Response to WSCC comments December 2017.

**WEST SUSSEX COUNTY COUNCIL
PLANNING SERVICES CONSULTATION**

SUBJECT: LU/278/17/RES - Approval of Reserved Matters following Outline Permission LU/47/11 for Construction of the southern section of the Lyminster Bypass, including northern and southern roundabouts, surface water drainage and landscaping. Departure from the Development Plan & affects a Public Right of Way.

LOCATION: North Littlehampton Strategic Development Site, Land West of Toddington Park, Toddington Lane, Littlehampton, BN17 7PP.

Landscape Proposals SLB2

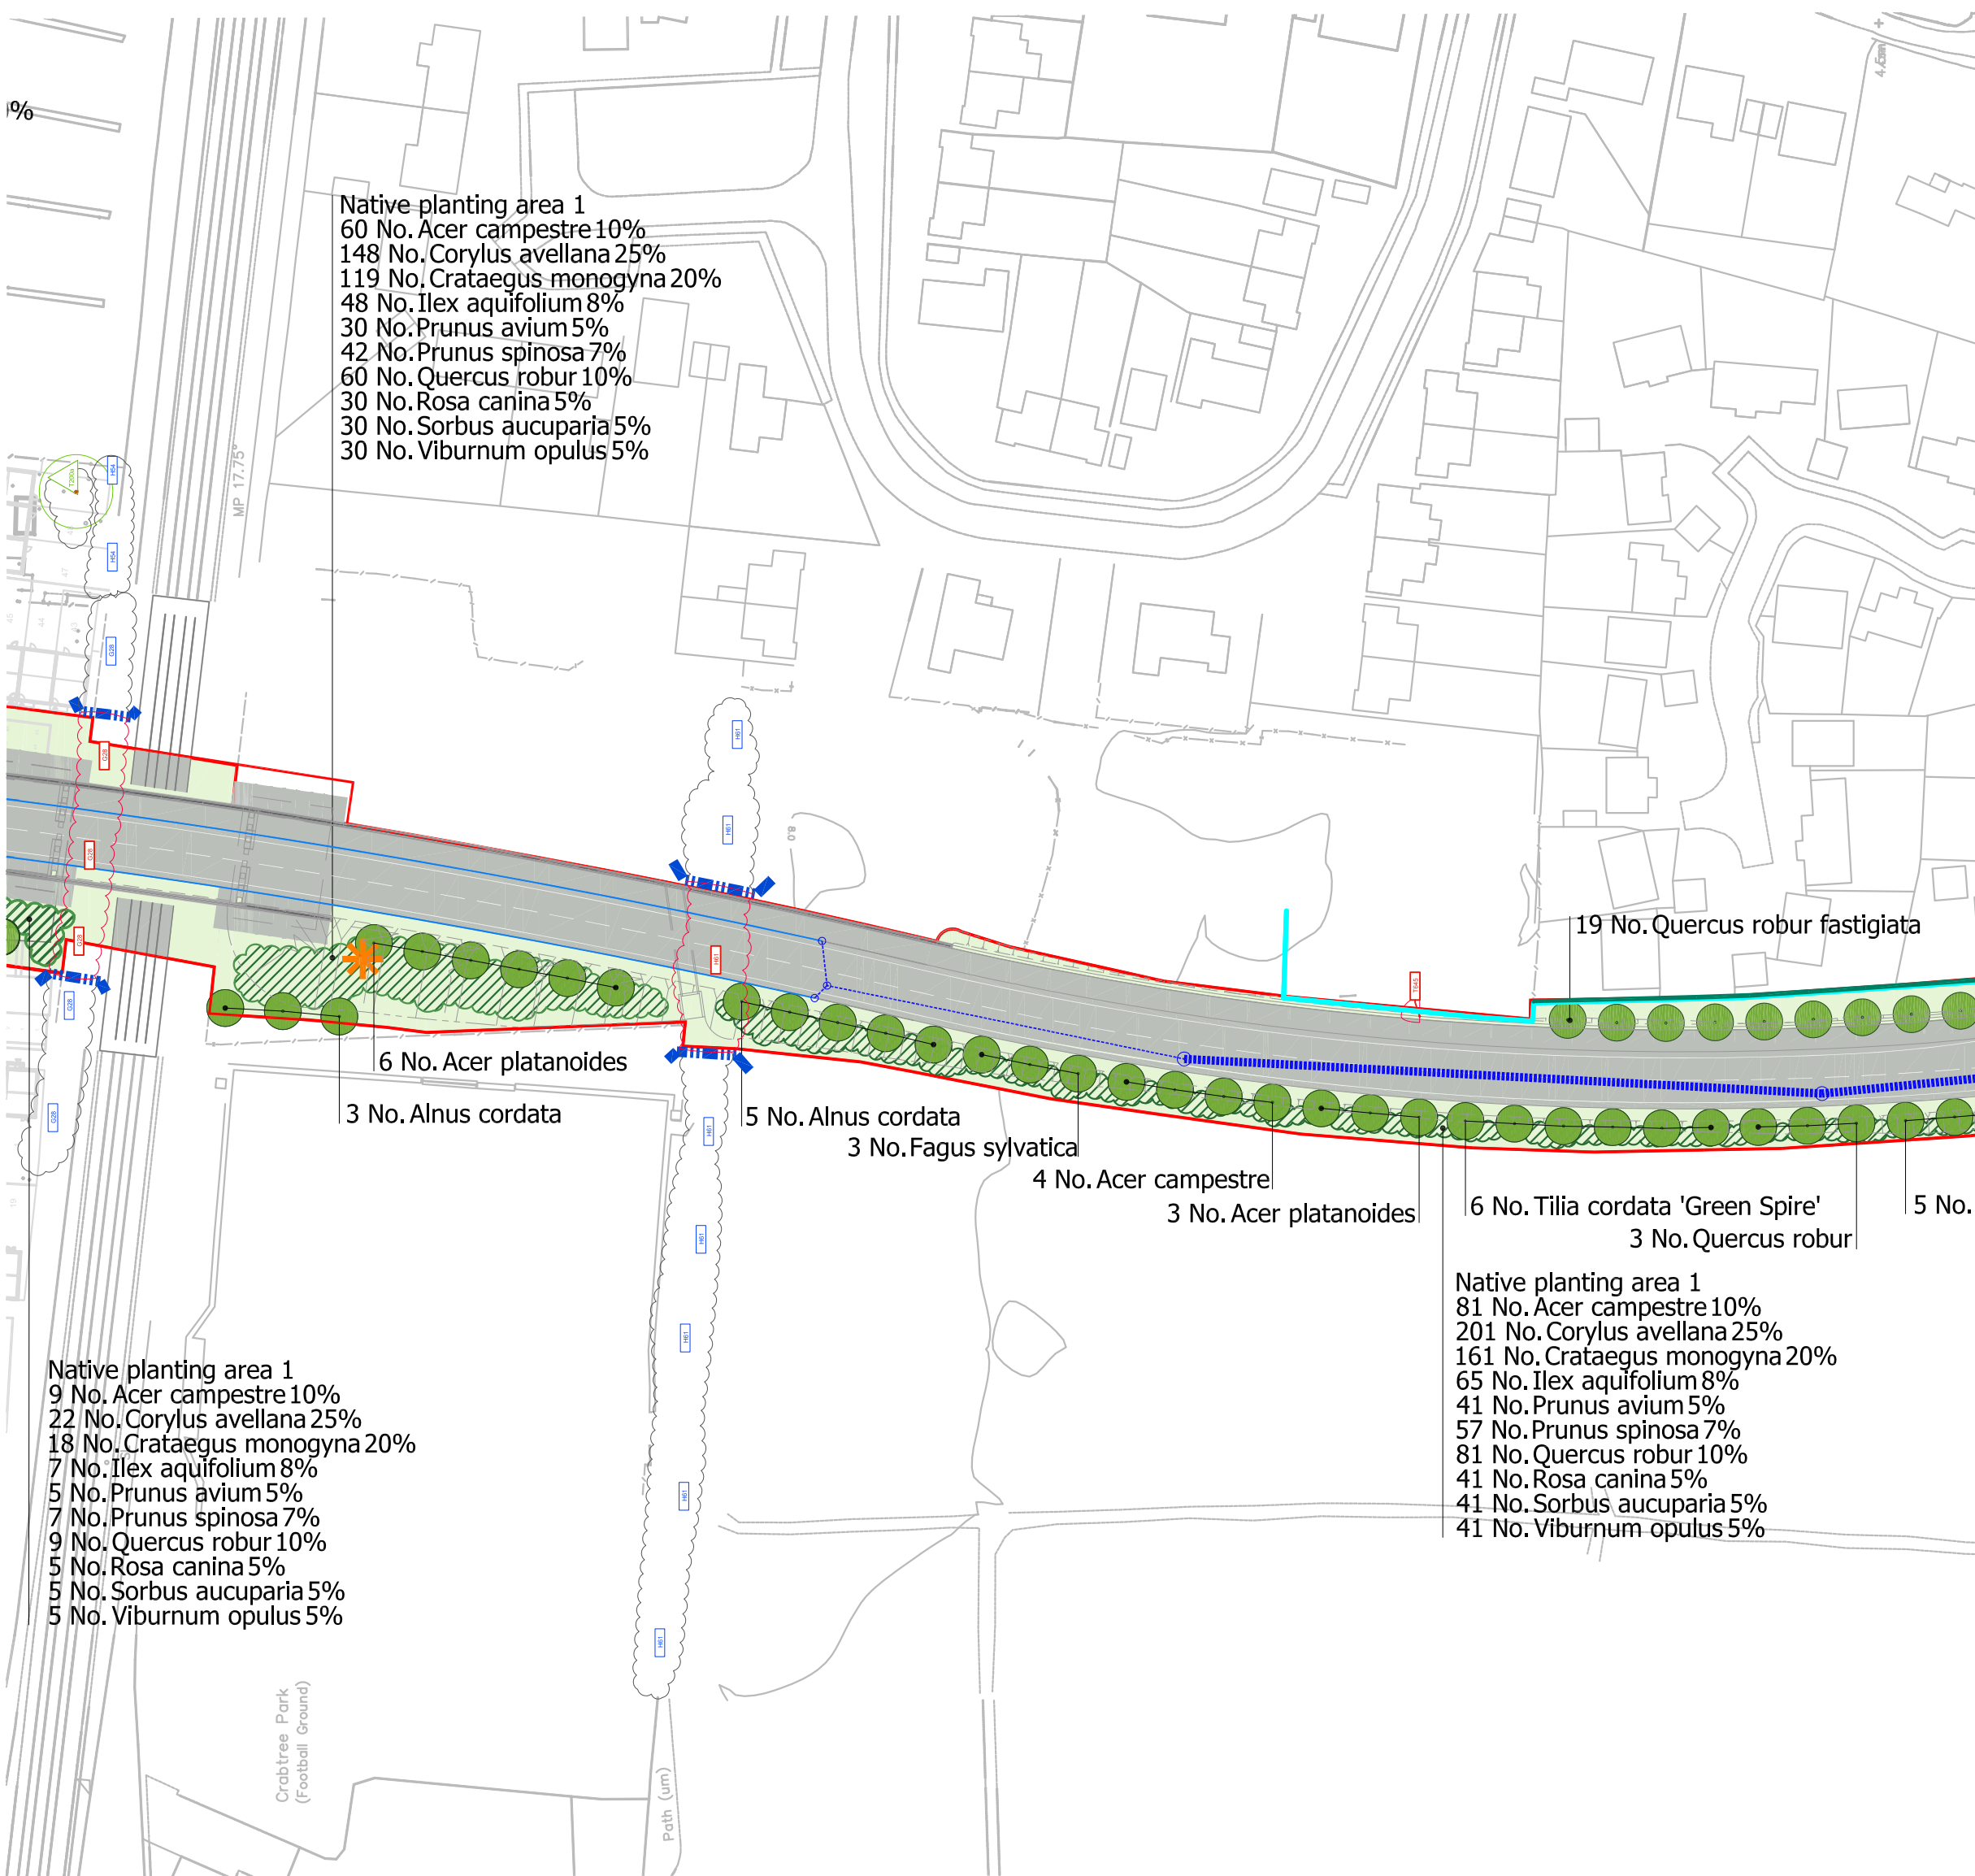
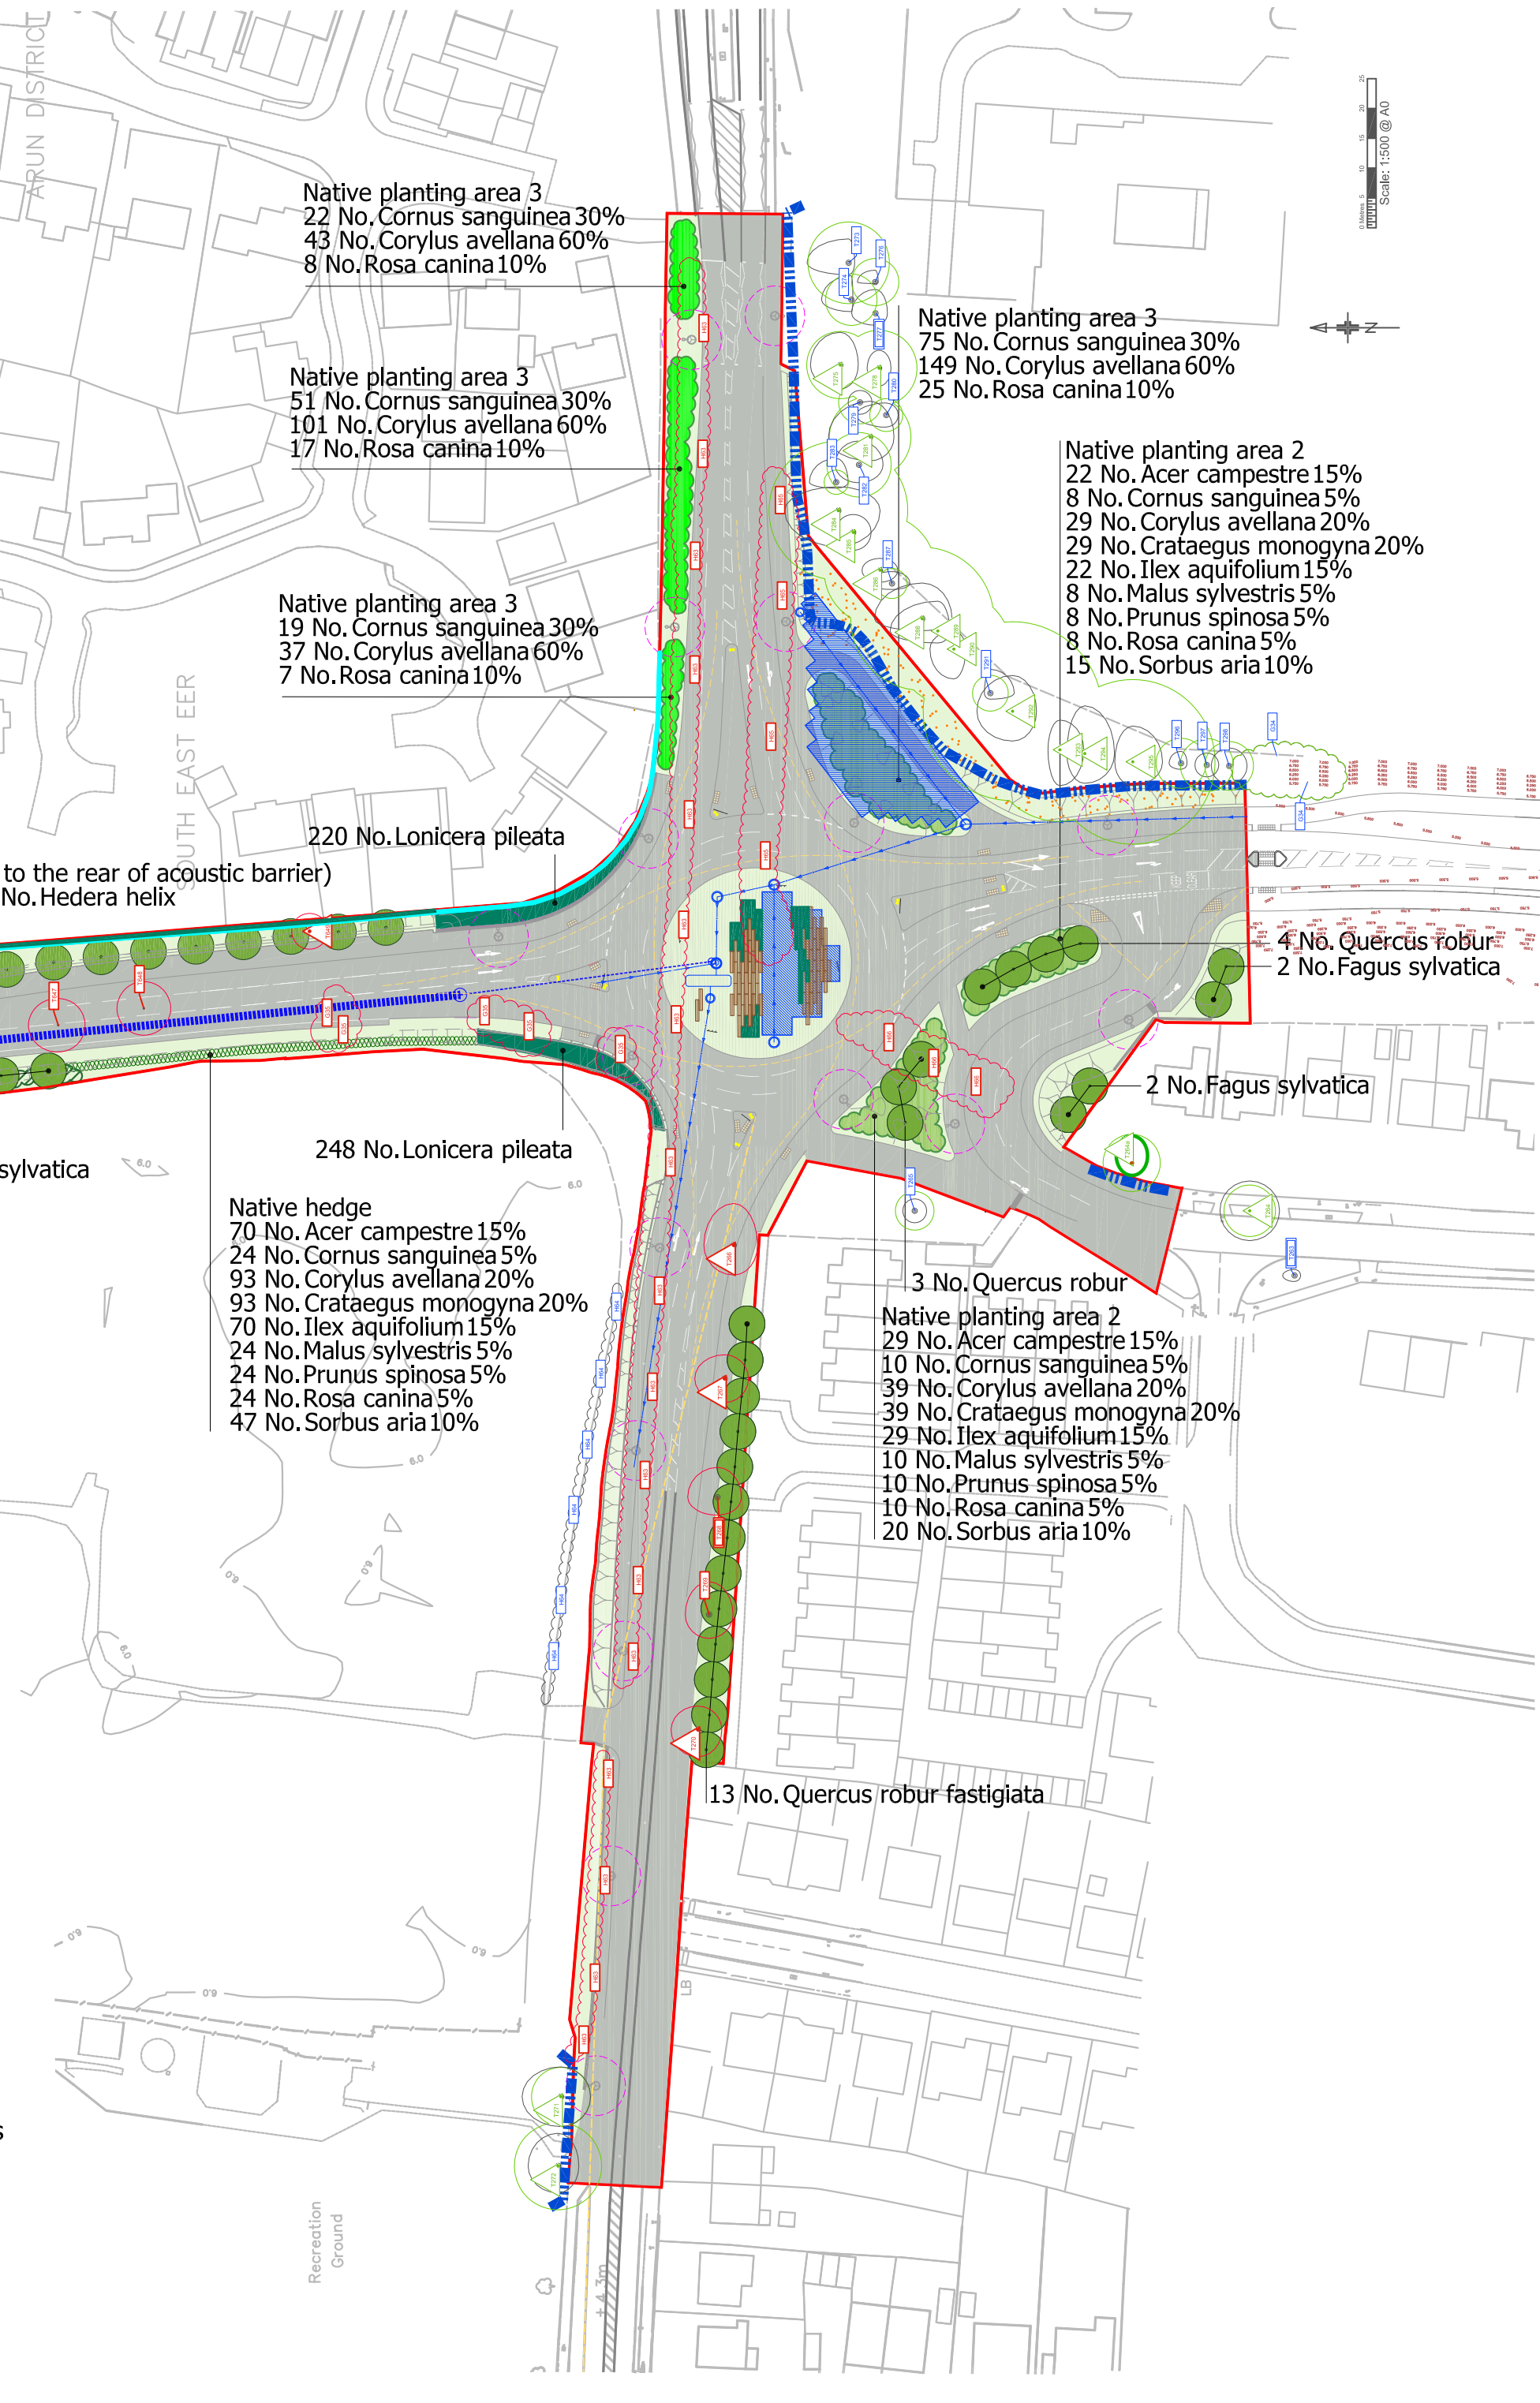
1. **WYG – Landscaping proposals SLB2 Plant Schedule 2 of 2 – A088461 SLB1-SLB4.dwg - August 2017.**
 - Visibility reqs. at points where visibility splays are required (ped and vehicular).

- Continuity of cycle route alongside re-aligned Highdown Drive (currently not overly clear on drawings) – maybe a detailed design consideration.
 - Safety barriers and the like on the bridges themselves and on the abutments need to be shown and checked leading up to the bridges must be suitably designed to cater for all users. Specifically on the bridges, guardrail heights where cyclists run close to them need to be higher than those used simply for footways. Applicant to show.

- Applicant to demonstrate that cycle path is wide enough and has enough clearance/suitable buffer-zone between carriageway.
2. **WYG – Landscaping proposals SLB1 Plant Schedule 1 of 2 – A088461 SLB1-SLB4.dwg - August 2017.**

- Please see the 'sticky notes' on the attachments to be read-alongside this report
 - If any blackthorn [*Prunus spinosa*] is proposed adjacent to any of the cycle paths, it should be omitted from the planting mix.
 Thorny shrubs (*Ilex aquifolium*, *Prunus spinosa*, *Rosa canina* and *Crataegus monogyna*) have been removed. *Sambucus nigra* and *Salix caprea* have been added to the mix.

LYMINSTER BYPASS - SOUTH
NORTH LITTLEHAMPTON
PROPOSED ROAD ALIGNMENT AND
CONTOURS

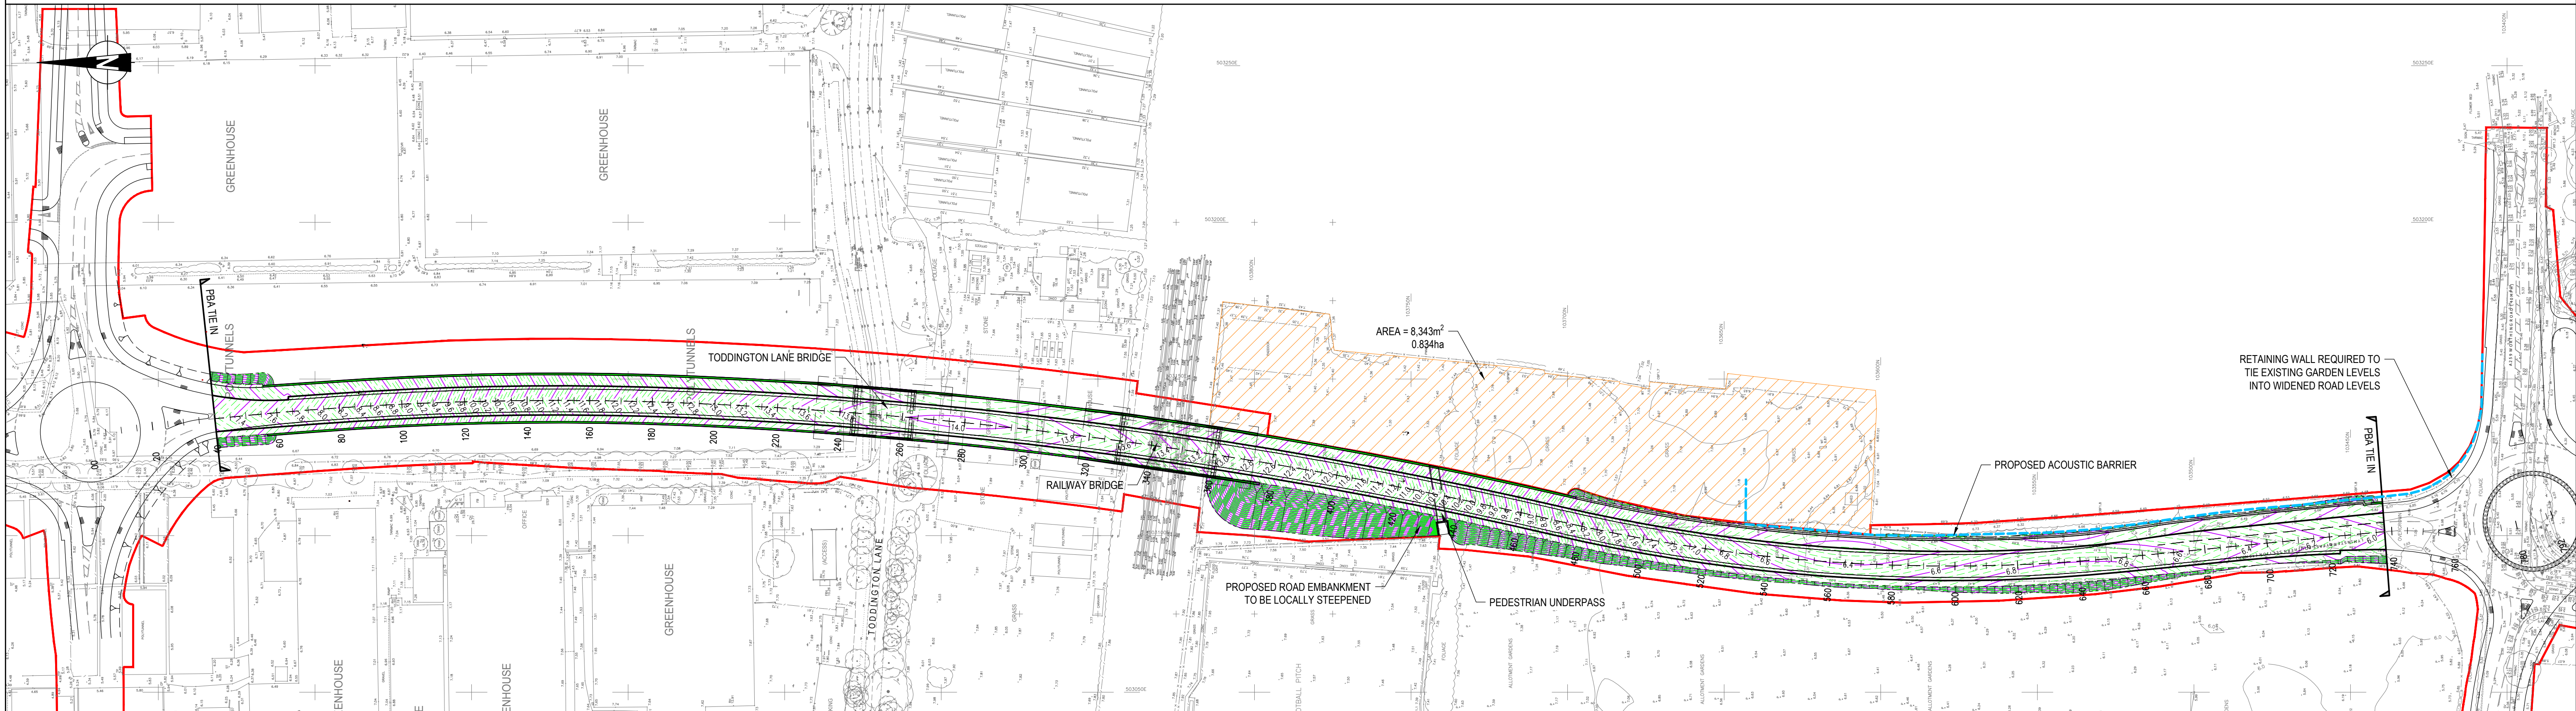
Alignment seems to suggest that it achieves a desirable minimum SSD forward visibility envelope for an 85kph design speed, based on the drawings provided to date. This will be verified when the Design Check is provided and reviewed.

Please refer to design statement produced by PBA
